MEMORANDUM

TO: Jean Fraser, Planner
FROM: Lauren Swett, PE
DATE: August 30, 2017
RE: One Joy Place, Level III Site Plan Application

Woodard & Curran has reviewed the Level III Site Plan Application for the proposed development located at 1 Joy Place in Portland, Maine. The project involves the demolition of an existing vacant single family home and the construction of a proposed 12-unit condominium and associated improvements to Joy Place a Private Road accessing the site.

BRICK DRIVEWAY APRON

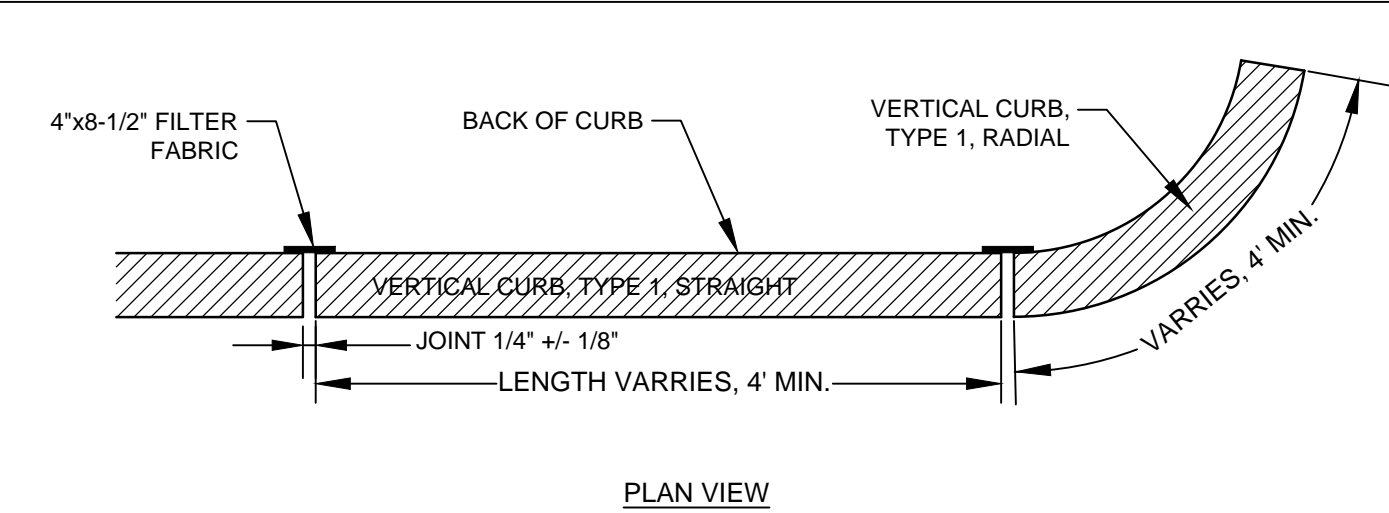
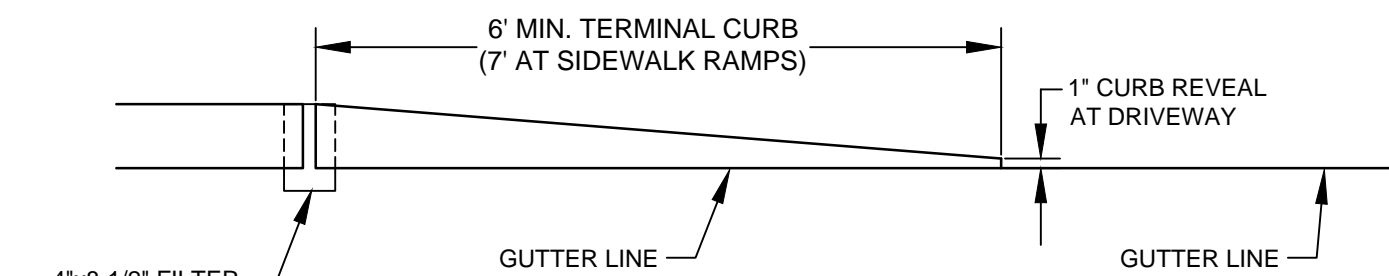
- 2) The detail and plan view provided for the brick driveway apron is not in conformance with the City of Portland's Technical Manual. The standard requires a 12" bituminous strip at the base of the driveway where the Applicant is currently showing a flush granite curb. Any variation from the standard will require approval from the City.
